# Charlotte Department of Transportation

## Memorandum

**Date:** March 10, 2008

**Subject:** Rezoning Petition 08-057: Located on the south side of East 36th Street between North Davidson Street and the Norfolk Southern Railroad

FOR PUBLIC HEARING PETITION #: 2008-057
 REZONING SURVEY OF:
DEBORAH MICHELLE NORKETT
 LOTS 3 & 4, BLOCK 1,
 MAP BOOK 230, PAGE 14
 446 EAST 36TH STREET
 CITY OF CHARLOTTE, MECKLENBURG COUNTY, N.C.
 DEED REFERENCE: 8460-388
 TAX PARCEL: 083-084-19

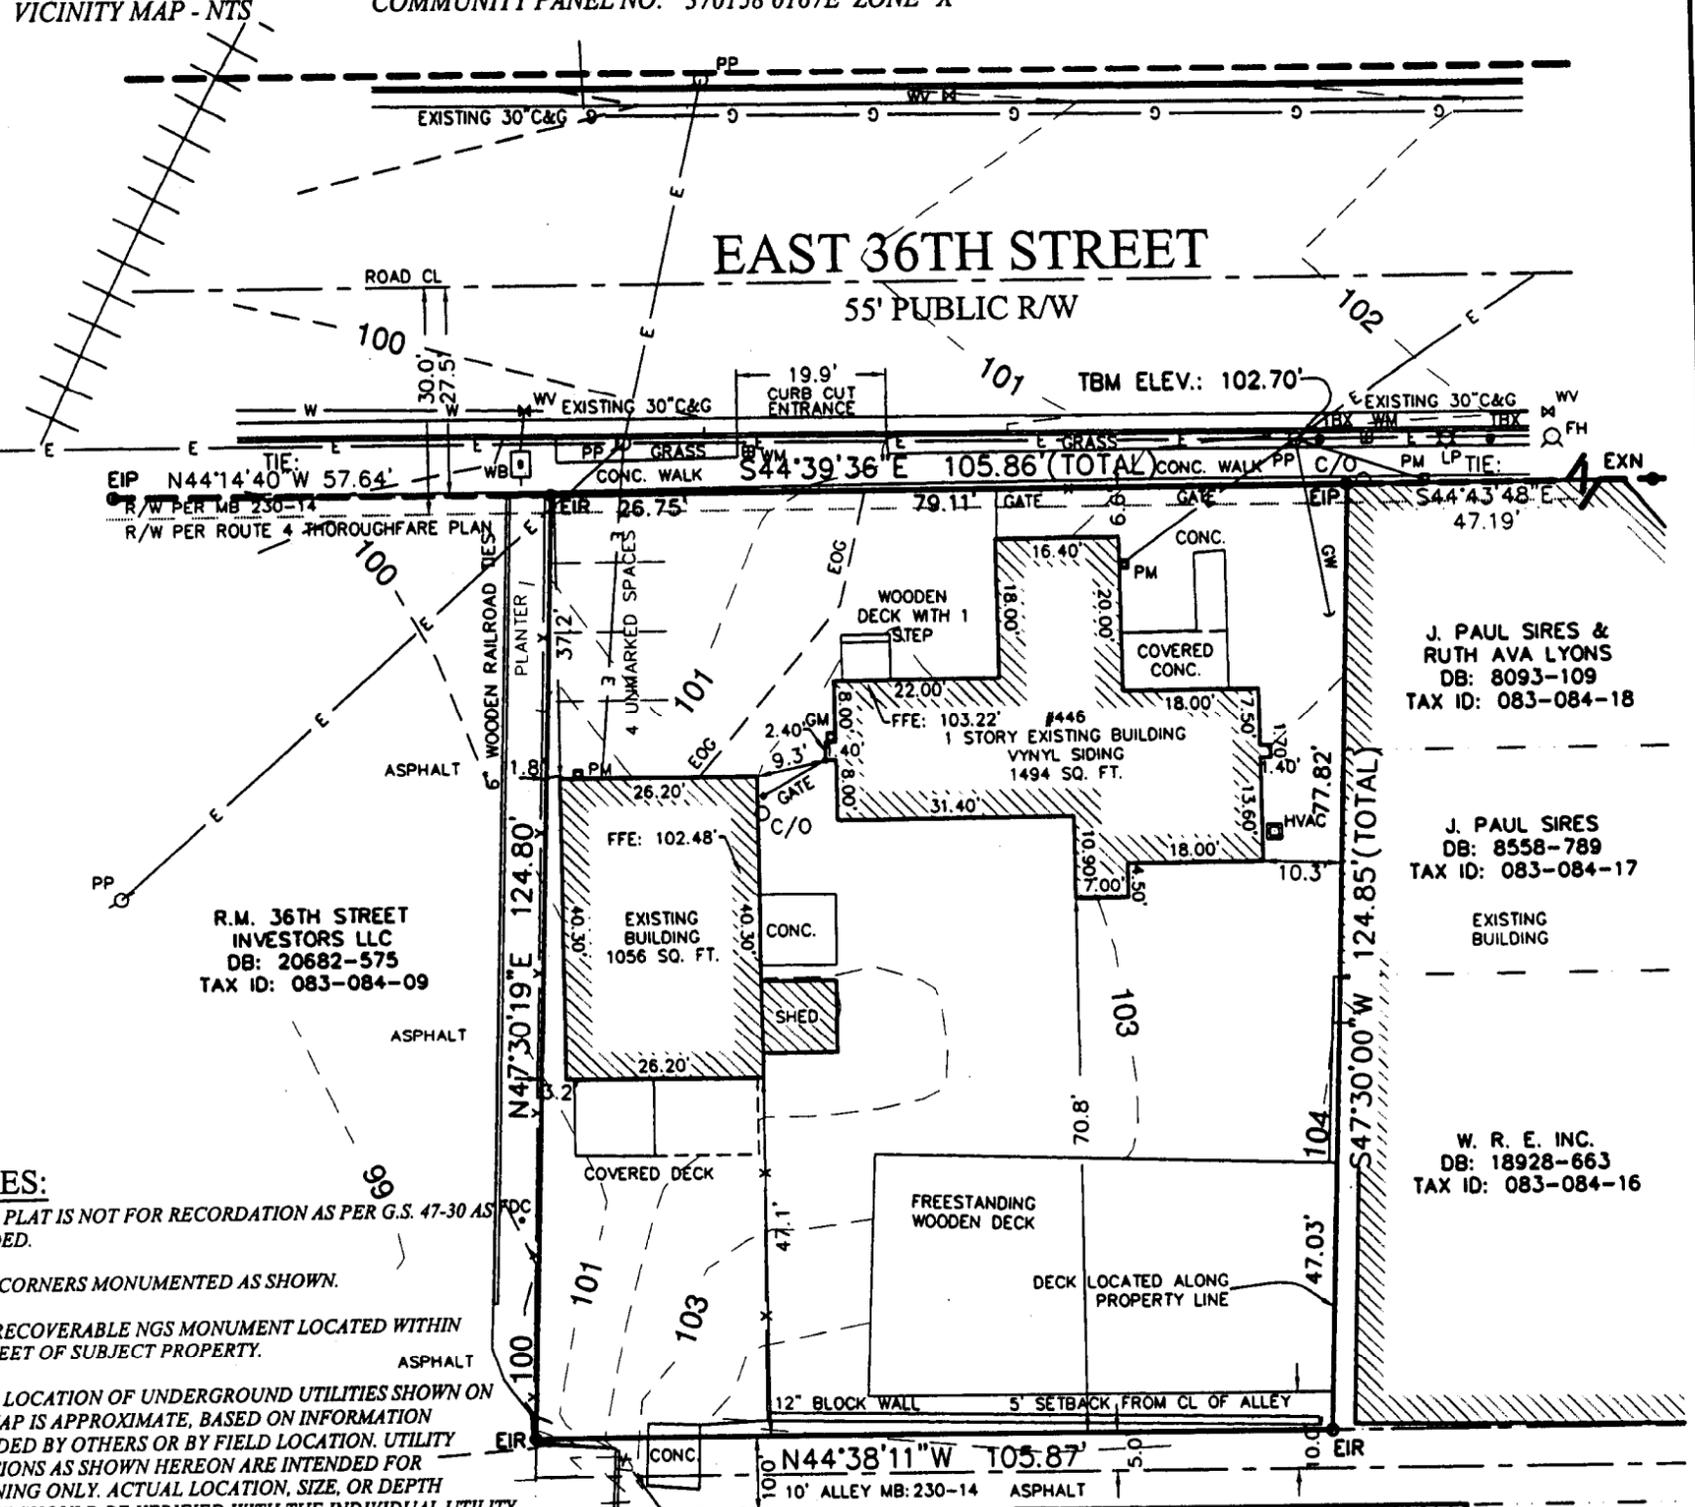
1. A site plan is needed (survey provided) showing any driveways, off-street parking and sidewalks in order to fully-evaluate the petition.

1. East 36<sup>th</sup> Street is classified as a Main Street using the street typology in the Urban Street Design Guidelines (USDG). As such, driveways are strongly discouraged, while wider sidewalks are strongly encouraged.

2. While the NS District requires 8' planting strips and 6' sidewalks, Main Streets need a minimum of 10-foot sidewalks (instead of 6') unless there are constrained conditions. Until a site plan is submitted and we are able to evaluate, we do not know whether there are constrained conditions.

East 36<sup>th</sup> Street is a minor thoroughfare inside Route 4 requiring a minimum of 60 feet of right-of-way. The developer/petitioner should convey right-of-way in fee simple title to meet this requirement, measuring 30 feet from the centerline of the roadway.

Adequate sight triangles must be reserved at the existing/proposed street entrance(s). Two 35' x 35' sight triangles are required for the entrance(s) to meet requirements. All proposed trees, berms, walls, fences, and/or identification signs must not interfere with sight distance at the entrance(s). Such items should be identified on the site plan.
